Timbers of Black Forest Subdivision No. 1

Final Drainage Report

PCD File No: **SF2616**

July 2026

PROPOSED DRAINAGE MAP

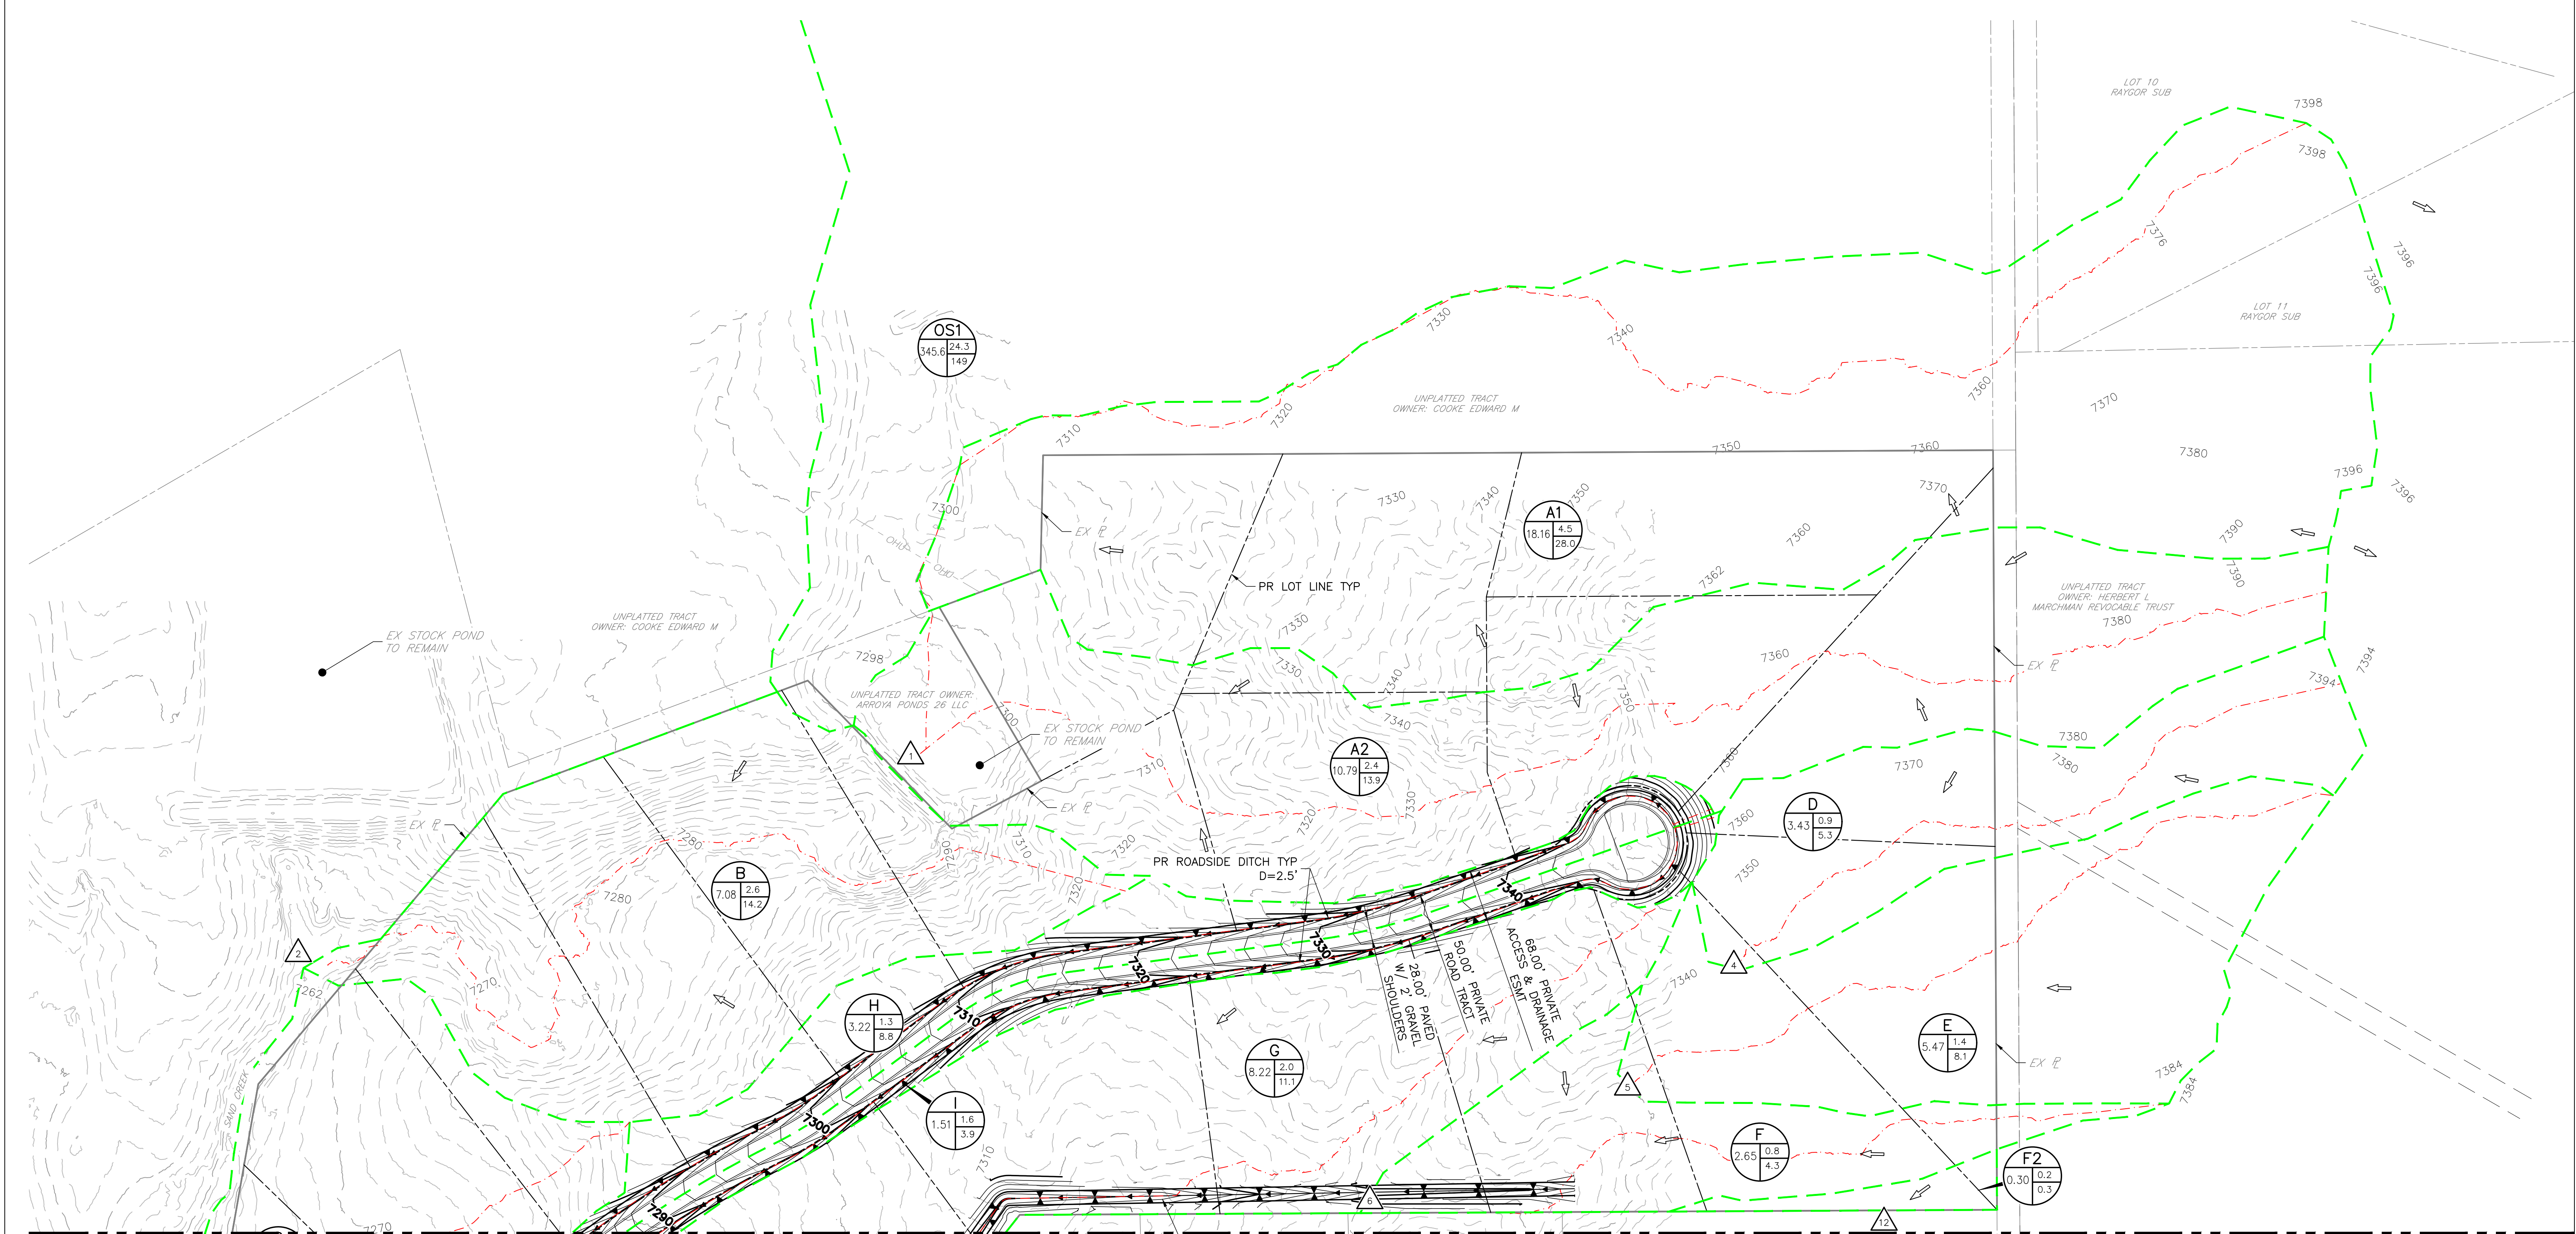
What happens if stock pond fails? Provide analysis of full undetained flow through swale and show limits of what 100 yr water surface could be. Provide small write up detailing this.

Basin L is 4.00 acres of proposed 2.5 acre lots and private roadway. Basin L stormwater ($Q_5 = 1.5$ cfs $Q_{100} = 2.6$ cfs) collects in a proposed, roadside swale to DP11 ($Q_5 = 2.0$ cfs $Q_{100} = 4.1$ cfs) and combines with Retreat at Timber Ridge Filing 4 Basin OEX-4. DP11 is captured by a private 18" RCP culvert and piped under the private roadway towards DP3. [What are the flows from this basin?](#)

If Basins A1, A2 & B go to the stock pond, where is water quality being provided for these basins?

Discuss exclusions for untreated basins
